Our Case Number: ABP-317121-23

Re: BusConnects Swords to City Centre Bus Corridor Scheme
Swords to Dublin City Centre

Swords to City Centre Core Bus Corridor Scheme Submission (Ref. No. 317121)

Submitted on Behalf of:
O'Scanail Veterinary Surgeons,
Milton Fields, Pinnockhill, Swords, Co. Dublin (Eircode Nos. K67 A4A8 & K67YX67)

Programme Title: BUSCONNECTS DUBLIN			
CORE BUS CORRIDORS INFRASTRUCTURE WORKS			
Drawing Title: SWORDS TO CITY CENTRE CORE BUS CORRIDOR SCHEME FENCING AND BOUNDARY TREATMENT KEY PLAN			
Drawing File Name: BCIDB-JAC-SPW_KP-0002_XX_00-DR-CR-0001	Sheet Number: 01 of 01	Status: A	Rev: M01

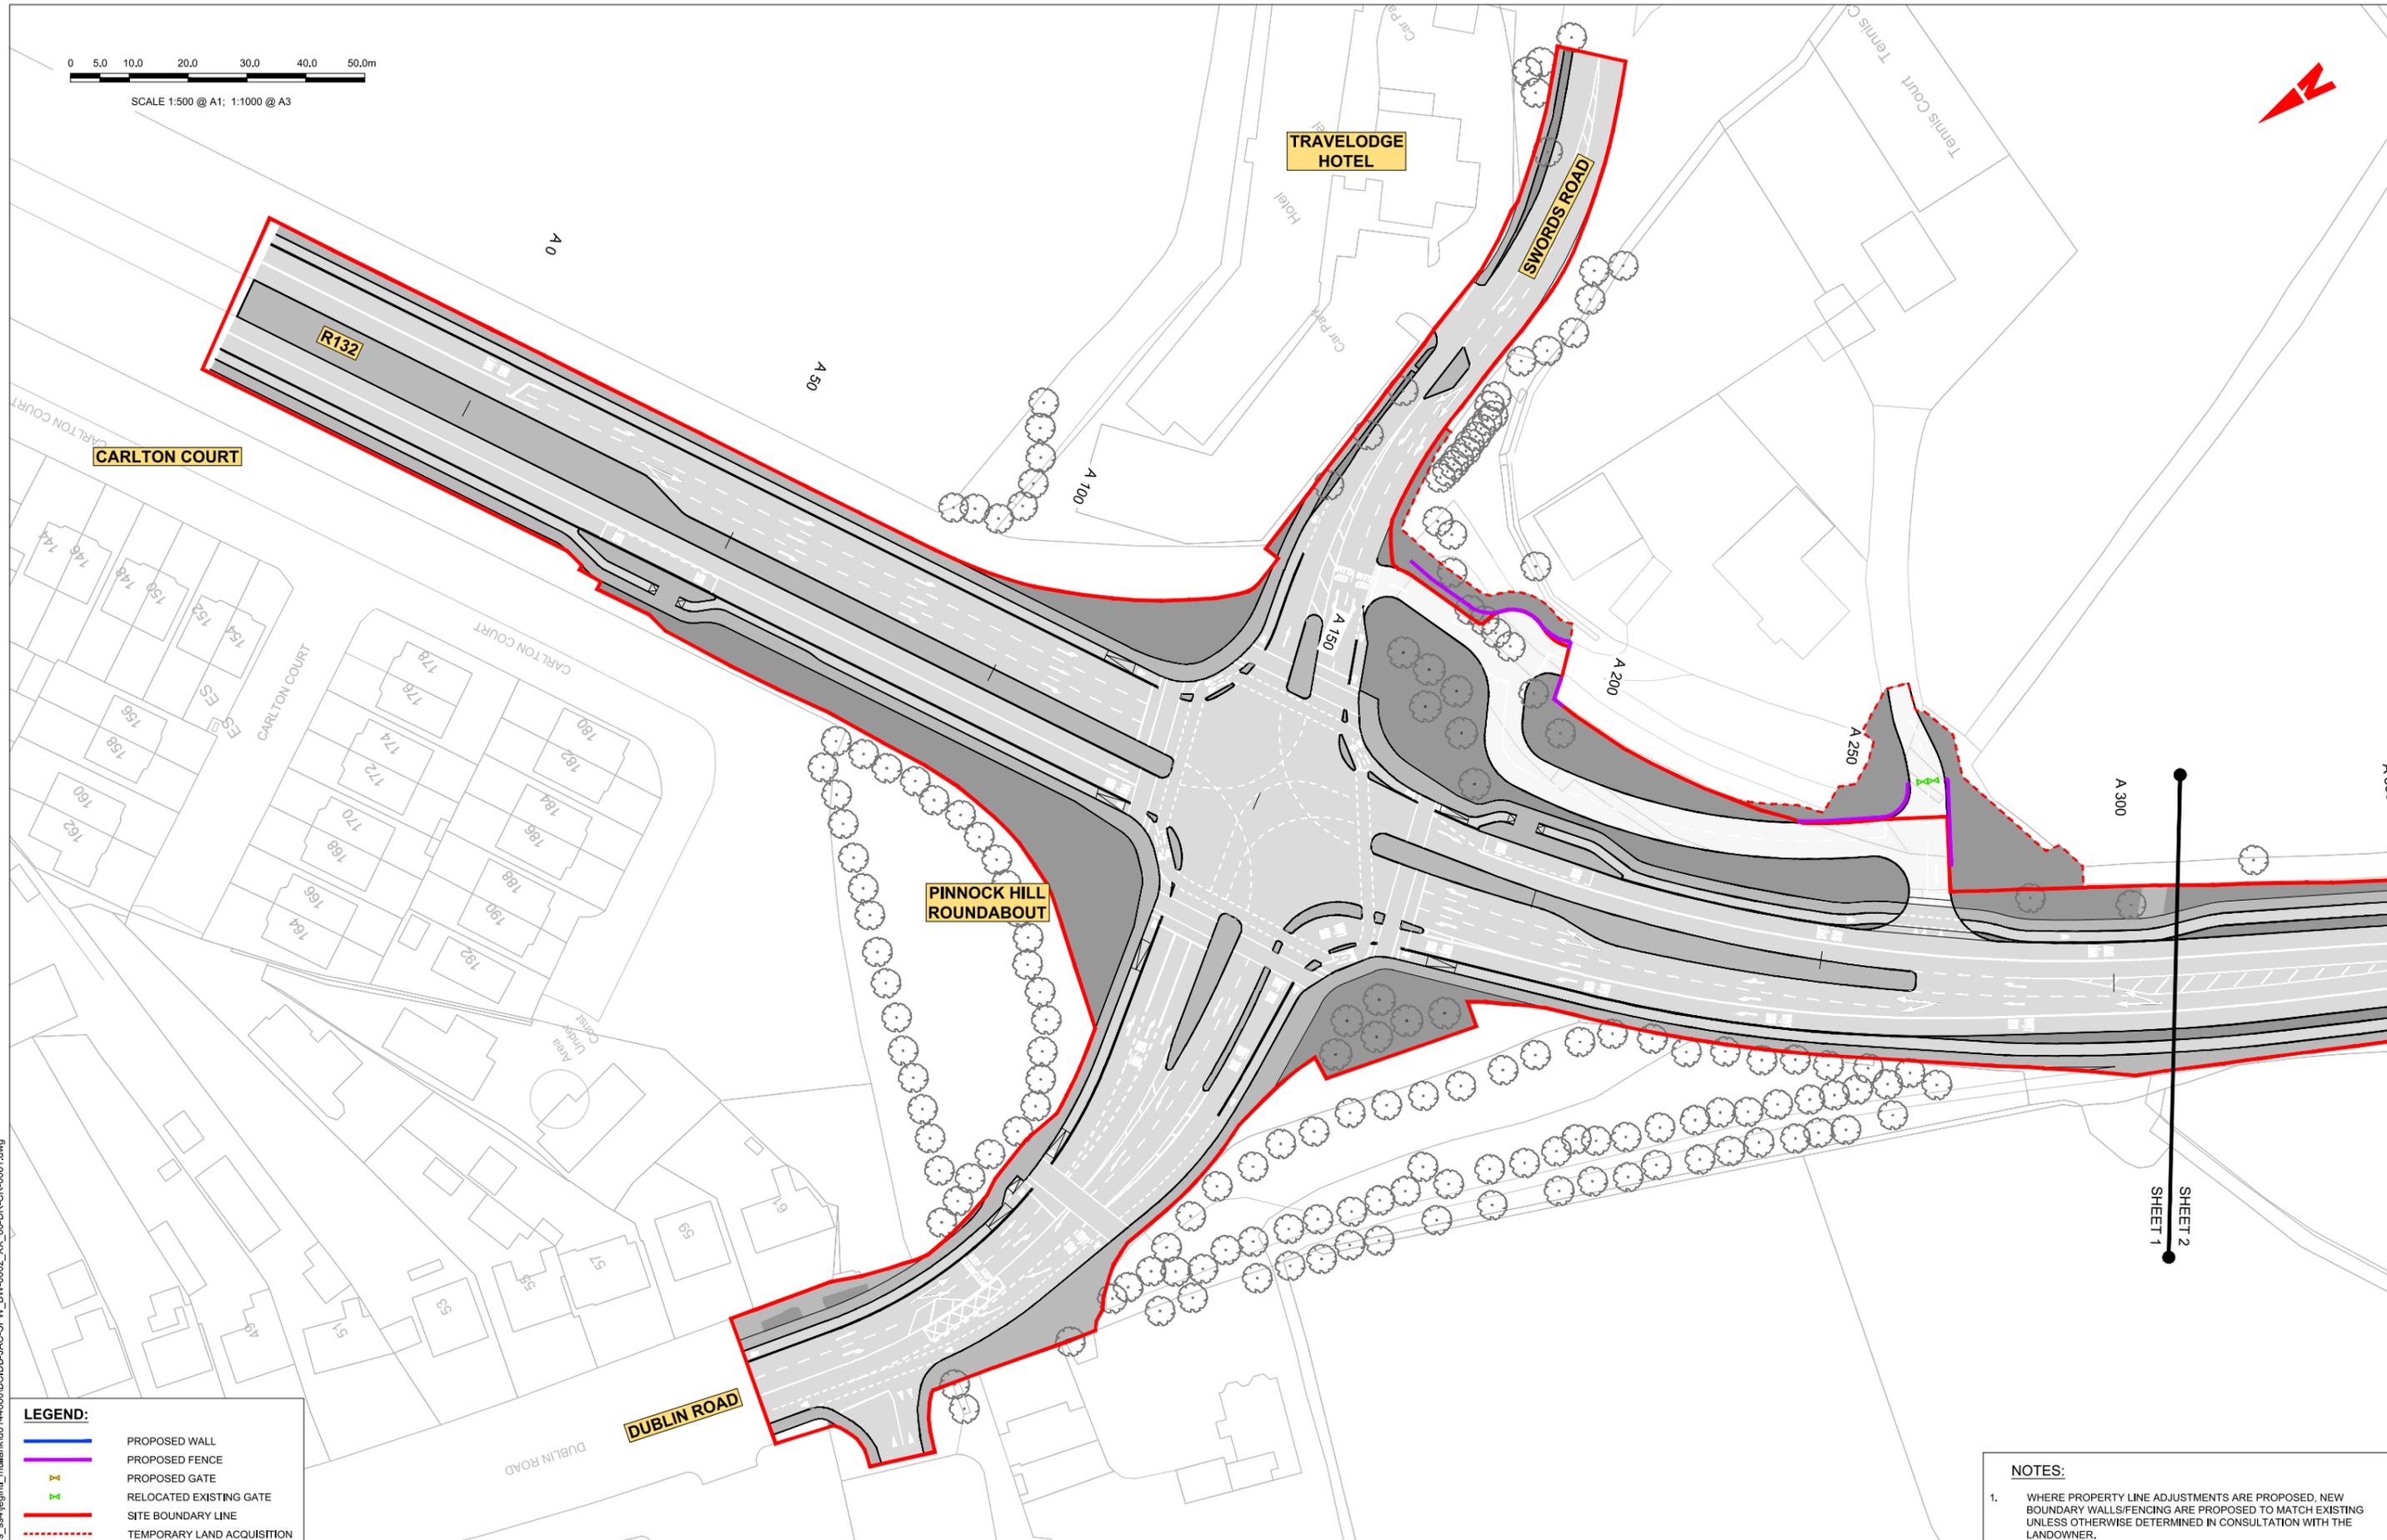
1. Significant extent of land acquisition for temporary use;
2. Significant extent of land acquisition (on permanent basis) for delivery of new slip road; and
3. Construction of new bus lane, cycle lane and bus stop to the immediate north of the site.

Further to the above, the scheme will also provide for a significant revision of existing boundary treatments/planting between the subject site and the adjoining road network along its northern and eastern boundaries.

As detailed on the general arrangement drawings, the subject scheme will compromise the accessibility of the site through the omission of 1 no. of the 2 no. longstanding vehicular access points to the site. The removal of a vehicular access point to the site is considered a critical impact of the subject scheme given the fact that only a handful of local customers travel to the facility by foot with no customers travelling by public transport as can be expected given the nature of the facility. The subject facility has enjoyed access through these lands since the inception of the practice, and all investment and spatial planning of their facility to date have relied on this access.

The proposed revision to the existing access arrangement will compromise the ability of HGVs to enter the site and transport larger animals for veterinary care. Consequently, our client is deeply concerned about the future success of their business and the potential ripple effects it may have.

It is noted that the existing facility has only 23 no. vehicular parking spaces with these spaces routinely occupied at full capacity over the course of a typical working day. It is considered that the works illustrated on the general arrangement drawings will result in the loss of 6 no. vehicular parking spaces and, more importantly, it will require all vehicles to perform excessive reverse manoeuvres, creating a traffic hazard. Our client is deeply concerned about the safety of their clients and the potential knock-on effects it may have on their insurance premiums.
